Please ask for: Ms Iqraa Malik
Email: iqraa.malik@terraquest.co.uk
Telephone: 0121 234 1390
Our Ref: AW/110/22/HH
Your Ref:
Date: 21st April 2022

Application for Planning Permission for Works or Extension to a Dwelling

Development: Erection of single storey front porch and first floor side/rear extension along with new cladding to first floor.
Location: 7 St Richards Way Aldwick PO21 3BD

SITE PLAN
SCALE 1:500

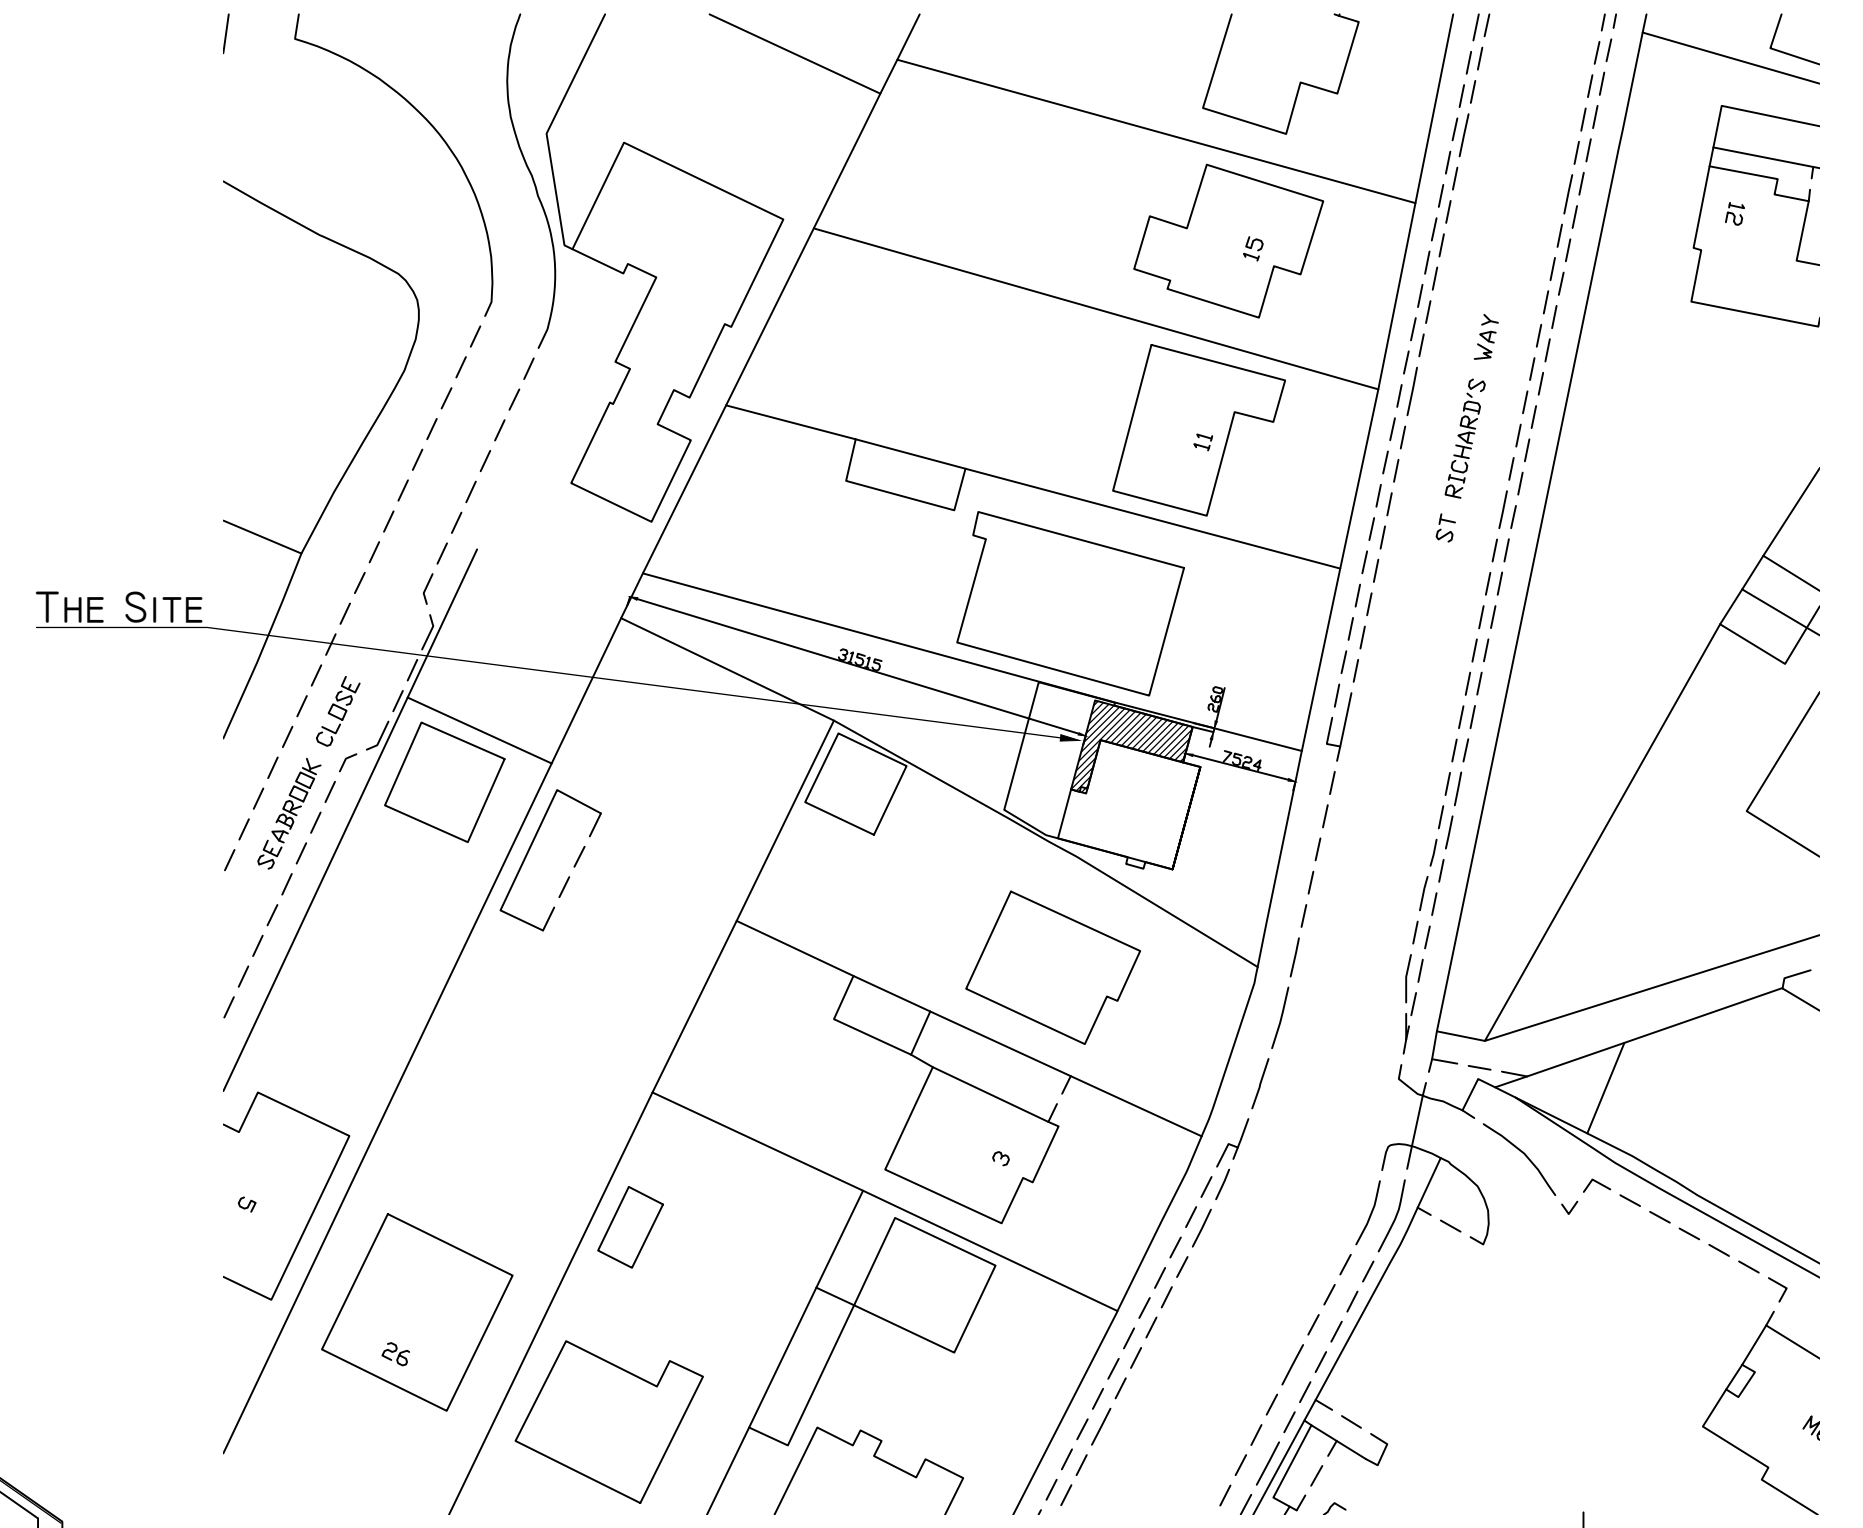
Block Plan

You are required to have dimensions from the proposed extension(s) to all site boundaries. Please amend.
